**City of Portland, Maine - Building or Use Permit Application**  
 389 Congress Street, 04101 Tel: (207) 874-8703, Fax: (207) 874-8716

<b>Permit No:</b> 07-0367	<b>Issue Date:</b>	<b>CBL:</b> 239A A004001
------------------------------	--------------------	-----------------------------

<b>Past Use:</b> Commercial/ Red Cross	<b>Proposed Use:</b> Commercial / Red Cross Install a freestanding 10' x 6' sign & 16" x 20' building sign	<b>Permit Fee:</b> \$226.00	<b>Cost of Work:</b> \$226.00	<b>CEO District:</b> 3
<b>Proposed Project Description:</b> Install a freestanding 10' x 6' sign & 16" x 20' building sign		<b>FIRE DEPT:</b> <input type="checkbox"/> Approved <input type="checkbox"/> Denied	<b>INSPECTION:</b> Use Group: Type	
		Signature:	Signature:	
<b>PEDESTRIAN ACTIVITIES DISTRICT (P.A.D.)</b>				
Action <input type="checkbox"/> Approved <input type="checkbox"/> Approved w/Condition <input type="checkbox"/> Denied				
		Signature:	Date:

**Comments:**  
4/11/2007-mes: left a message with sec. for Doug at Sign Design - The freestanding sign is too big and I need to know all the existing signage on the building (Red Cross).  
4/17/2007-mes: received a couple e-mails on Friday th

Double Sided, Interior Illuminated Sign Cabinet  
Lexan Faces W/ Vinyl Graphics

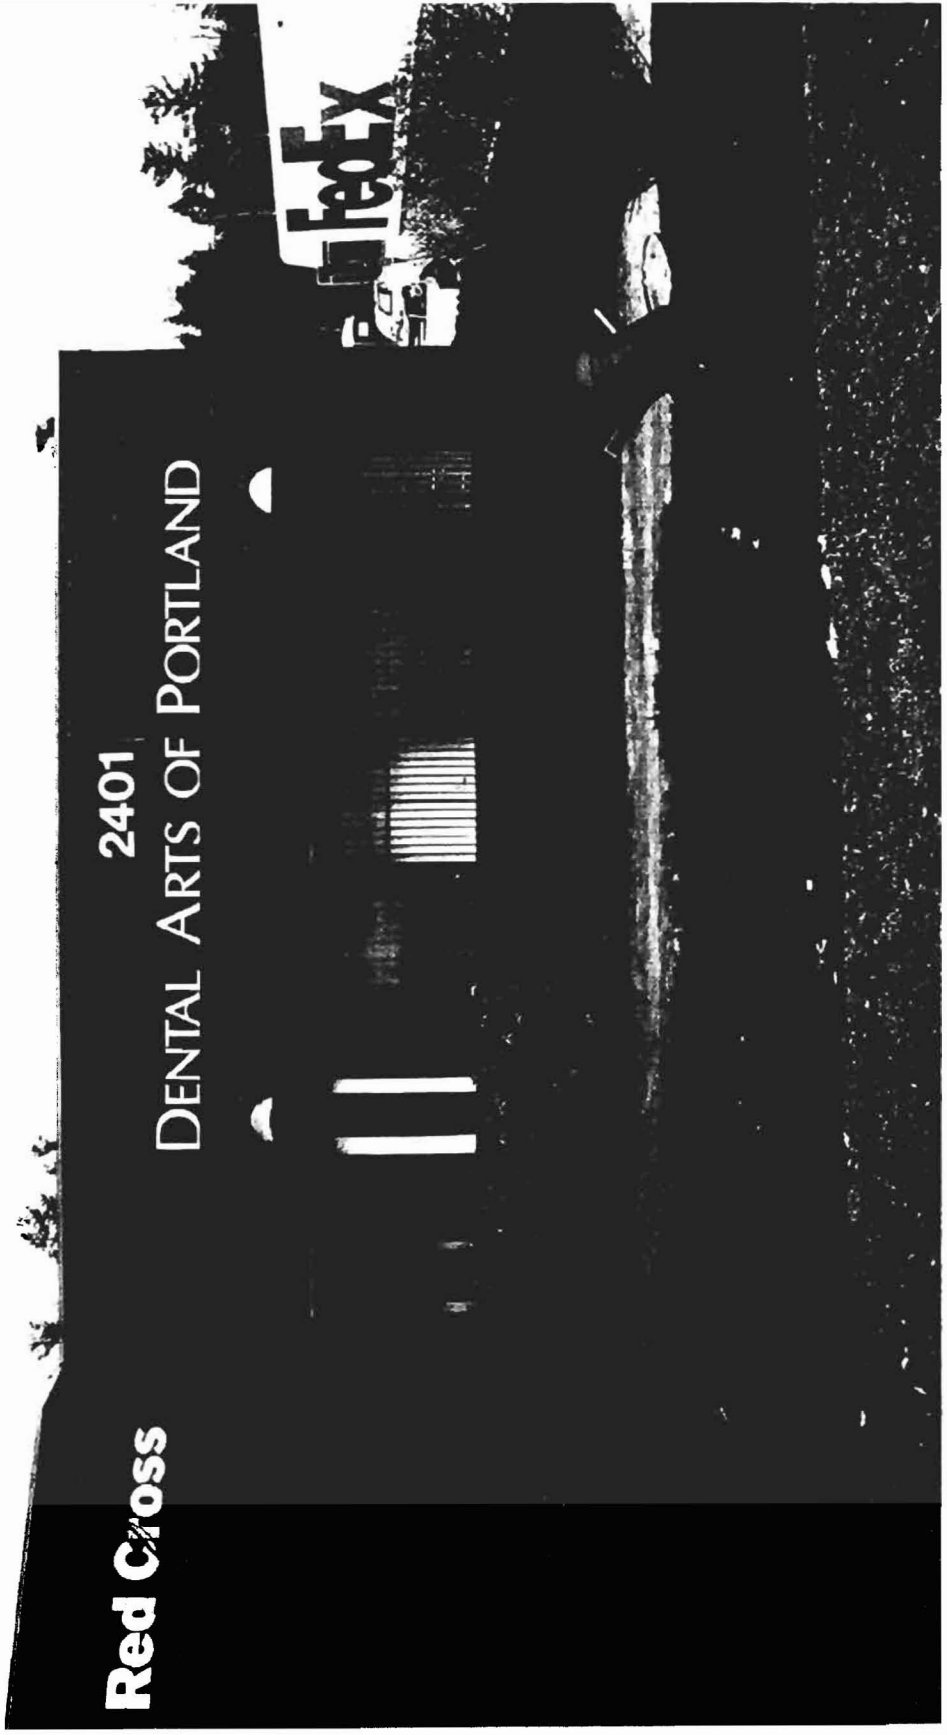
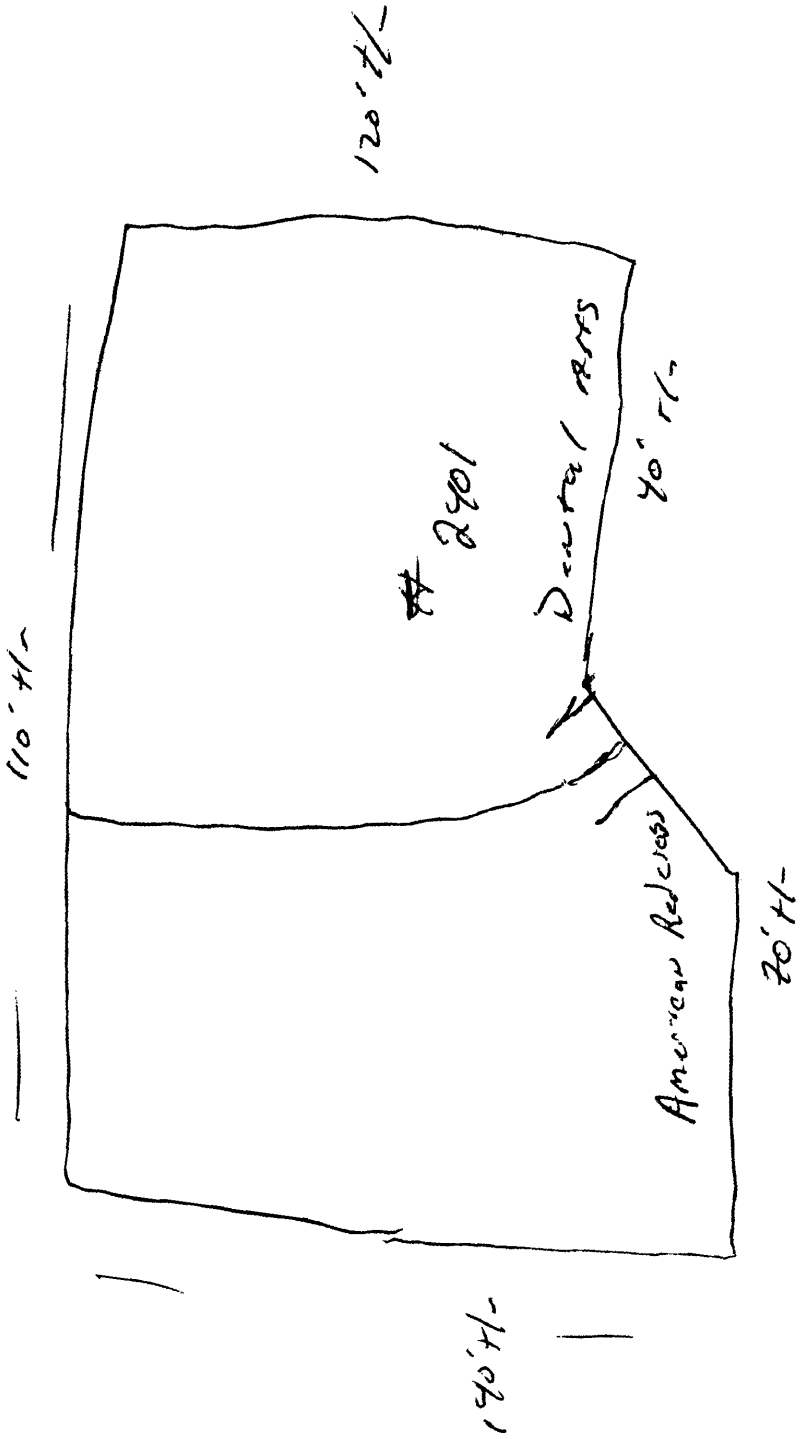
Doug,  
thank you. Is the free standing sign going to be at least 5' from the property lines?  
Marge

Please see the attached layout for the free standing sign. It has been revised to = 70 square feet.

*82" x 122" =  
10004 ÷ 144 =*

*OK 170" max  
Allowed*
